Planning Statement

Site: 27 Magdalen Road, Oxford, OX4 1RP

Proposal: Redevelopment of the Site to Provide
6no. Class C3 Dwellinghouses, with associated
Cycle Parking, Bin Storage, Amenity Areas and
Landscaping (Resubmission)

Date December 2023

Diagram C : Amended Proposals

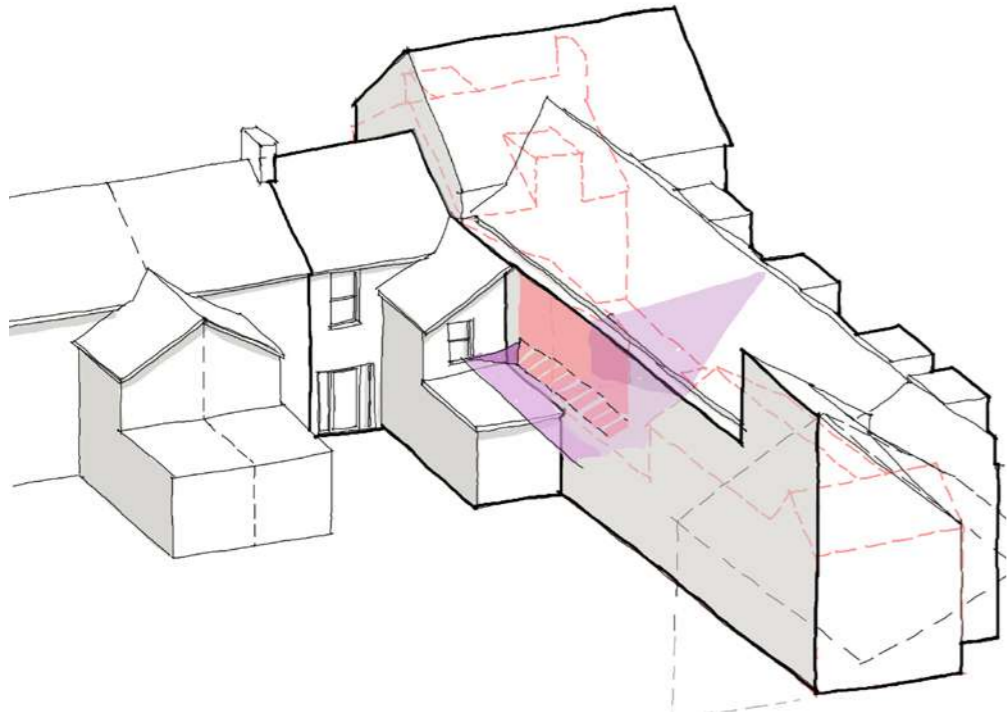
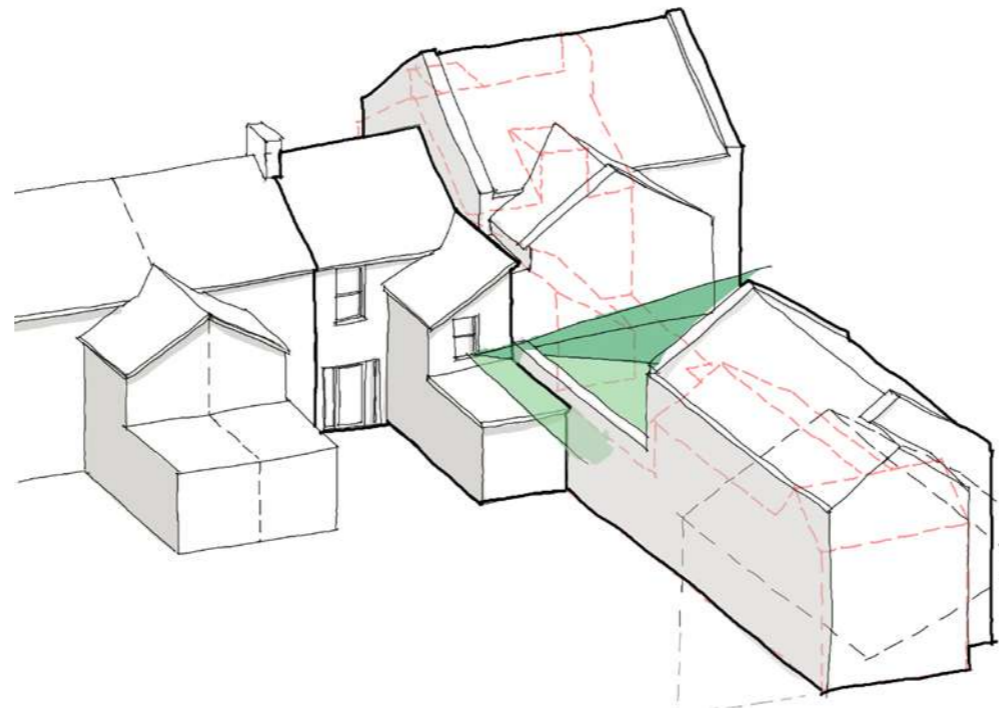
3.2 The Case Officer referred to the amount of development and number of units in what was thought by the Officer to represent over-development as the first concern, with a view that fewer units should be proposed, with the bulk and massing broken down and reduced.

3.3 A second area of concern expressed related to impact on 26 Magdalen Road, in terms of "*complete enclosure*", overbearing, outlook loss and loss of light to habitable rooms, citing Local Plan Policies RE7 and H14 for "*unacceptable amenity impacts*".

3.6 The scale, bulk and massing of the Original Proposal was deemed a robust interpretation of many other corner plots in the area. However, in looking to address the concern raised the Amended Proposal has a substantially reduced bulk and massing onto Hurst Street with removal of the middle apartment at first floor level. Together with removal of one of the two lower ground floor apartments this has reduced the development by 25%, to 6 apartments rather than the 8 in the Original Proposal, thereby markedly reducing the number and amount

- 3.11 Given the above, the Amended Proposal removes the middle apartment from the first floor level. As demonstrated in the DAS this means that there is now no harm to the residential amenity of those residing in 26 Magdalen Road, either in the property itself or in the garden, meeting in full the Officer's concern in relation to the amenity of 26 Magdalen Road.
